Application for a Non-Material Amendment Following a Grant of Planning Permission

Number	56
Suffix	
Property Name	
Address Line 1	Royal Lane
Address Line 2	
Address Line 3	Hillingdon
Town/city	Uxbridge
Postcode	UB7 8DN

Erection of single storey side extension

36167/APP/2025/3233

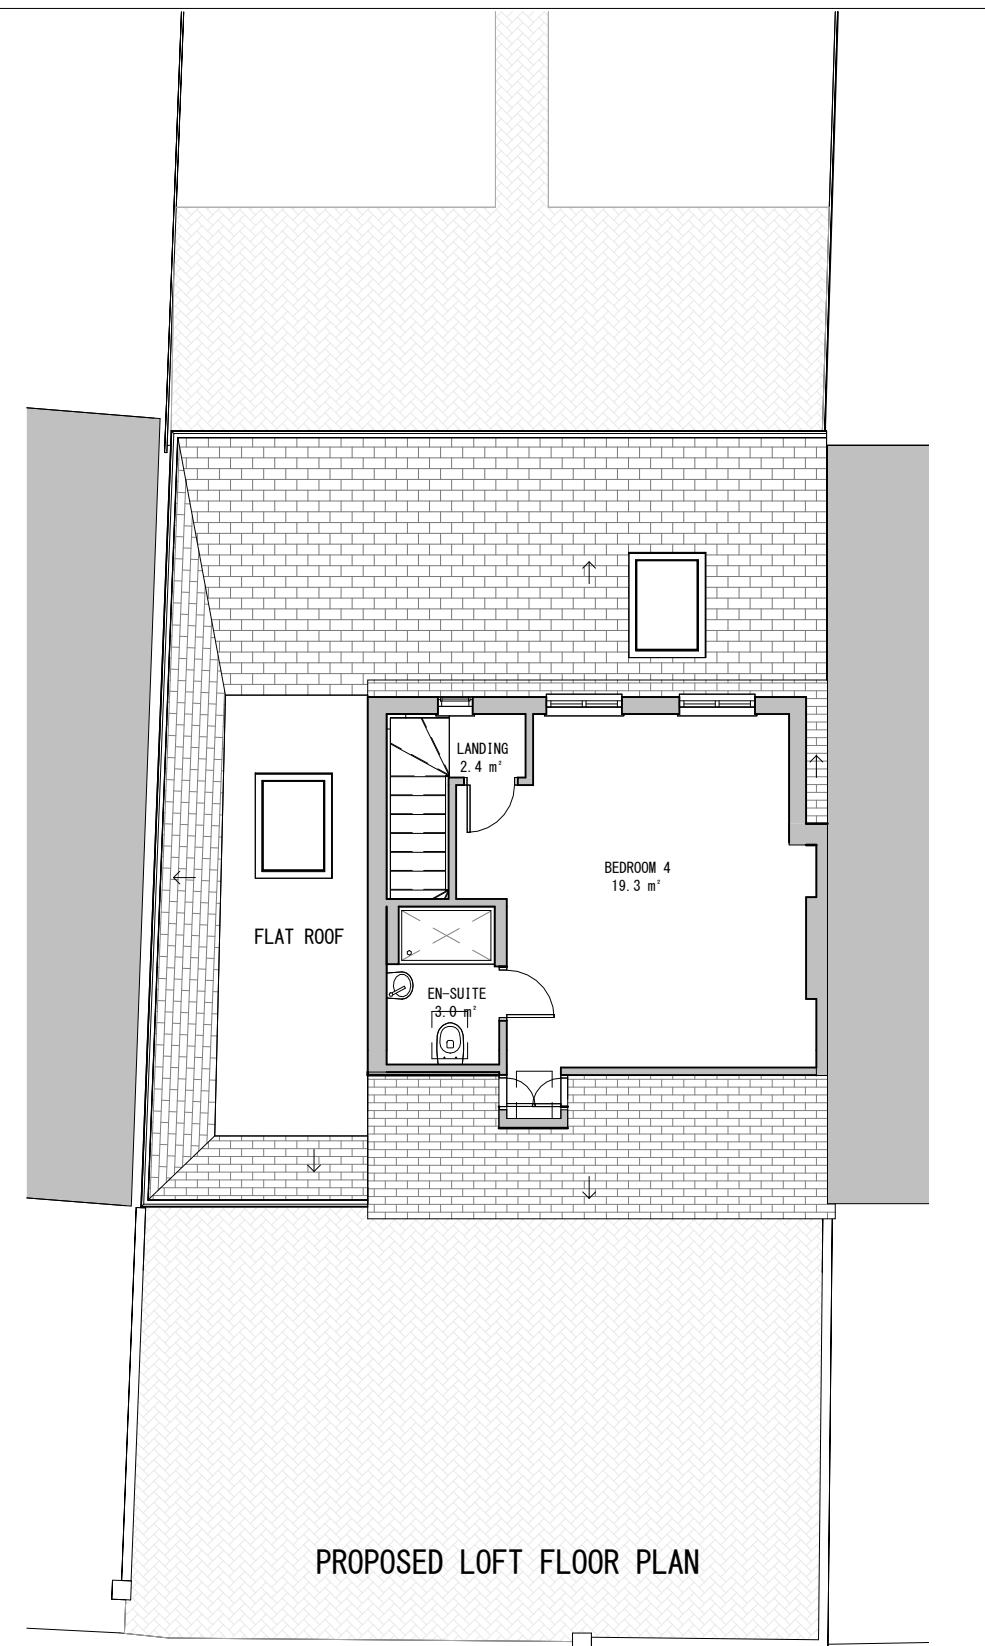
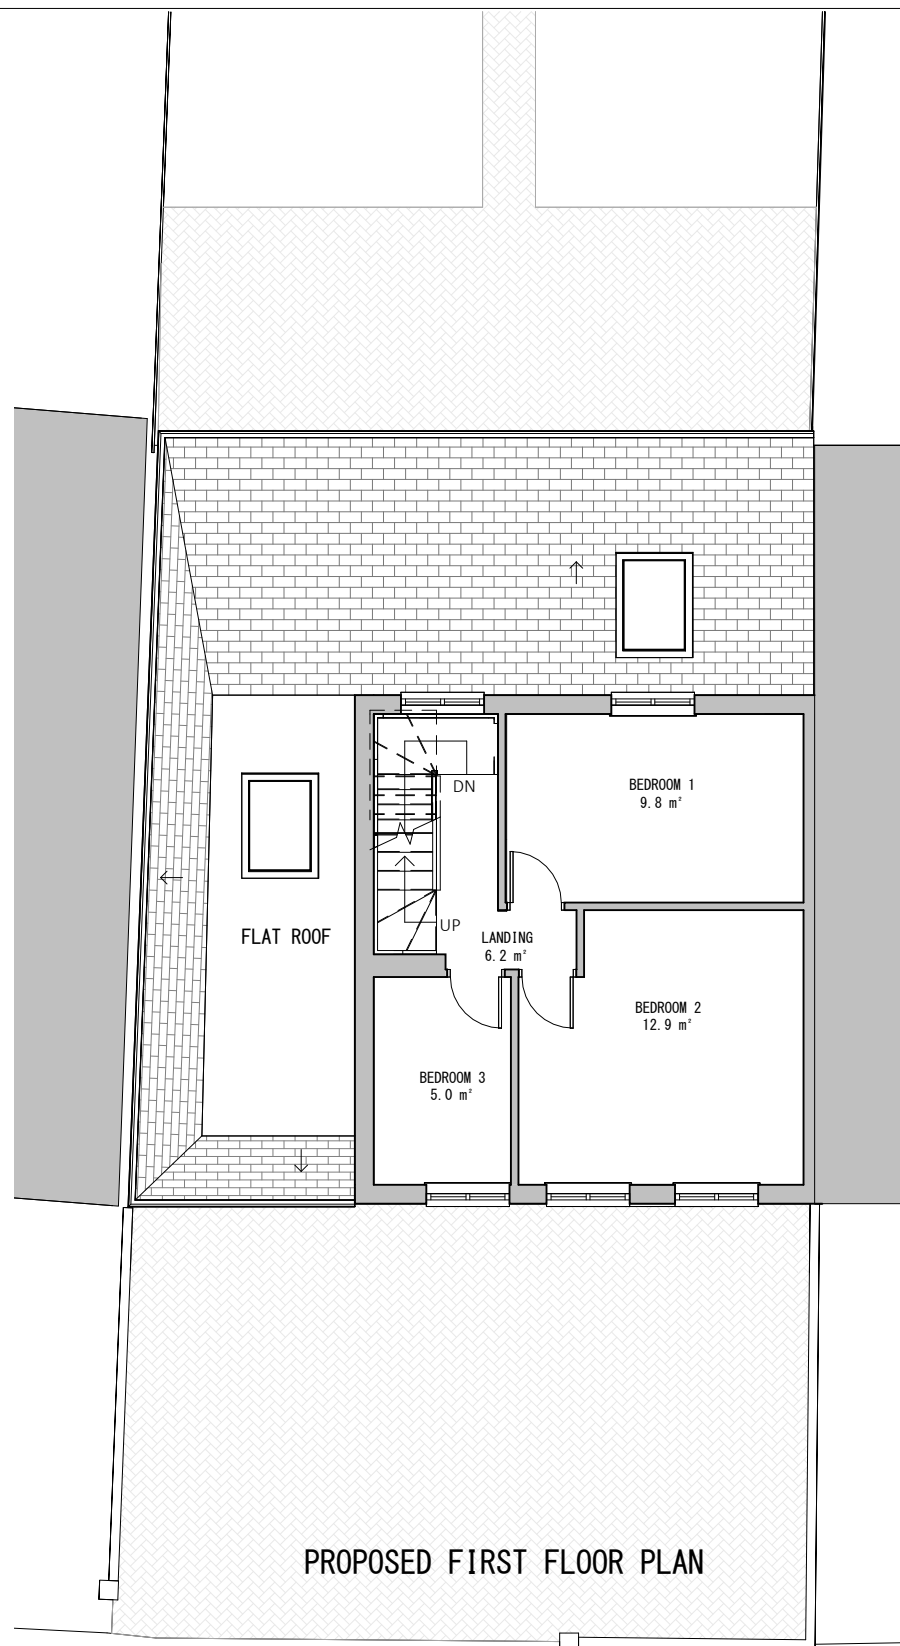
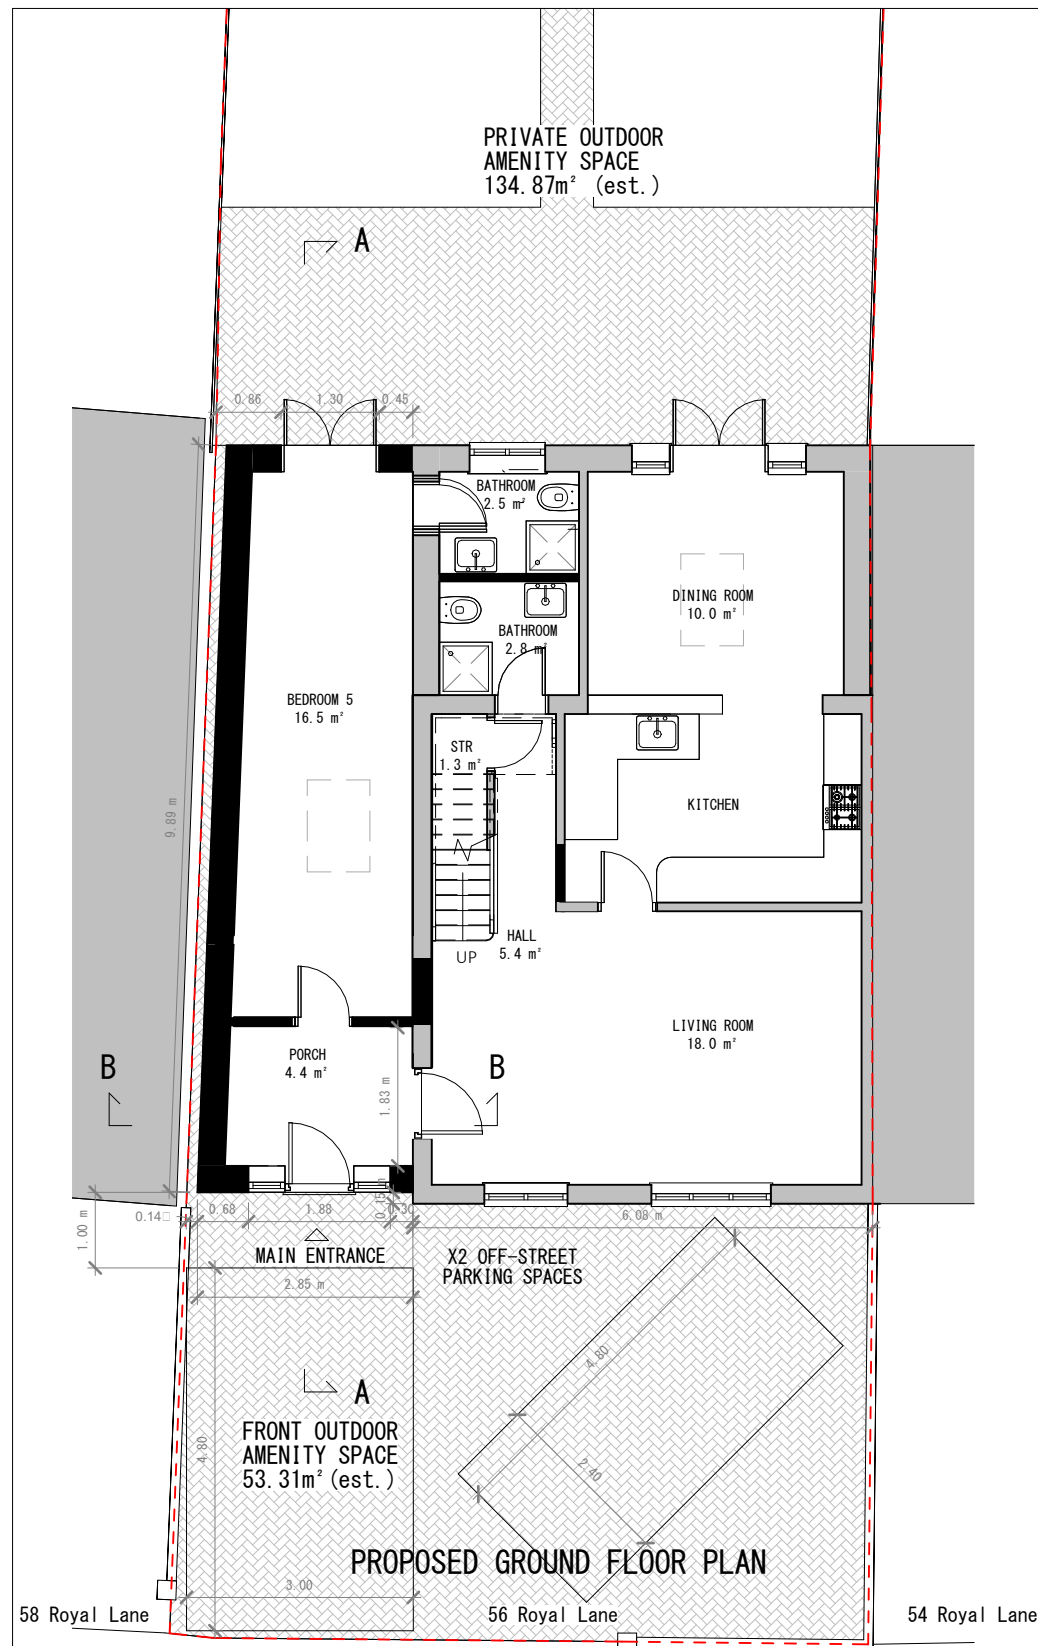
1. Relocated entrance hall and bedroom 5 partitioning wall.
2. Relocated existing main entrance door.
3. Split bathroom on ground floor to create x2 bathrooms.
4. New roof window for side extension in bedroom 5.

1. Increase bedroom 5 size being quite narrow and long.
2. In order to increase bedroom 5 size as per above.
3. Provide separate bathroom for bedroom 5, yet retaining existing ground floor bathroom albeit smaller in size.
4. Provide more daylight into the larger bedroom 5.

Drawing 03: Proposed Floor Plans dated 18/07/2026 Revision Suffix C.
Drawing 05: Proposed Roof Plan dated 18/07/2026 Revision Suffix C.
Drawing 07: Proposed Site Plan dated 18/07/2026 Revision Suffix C.
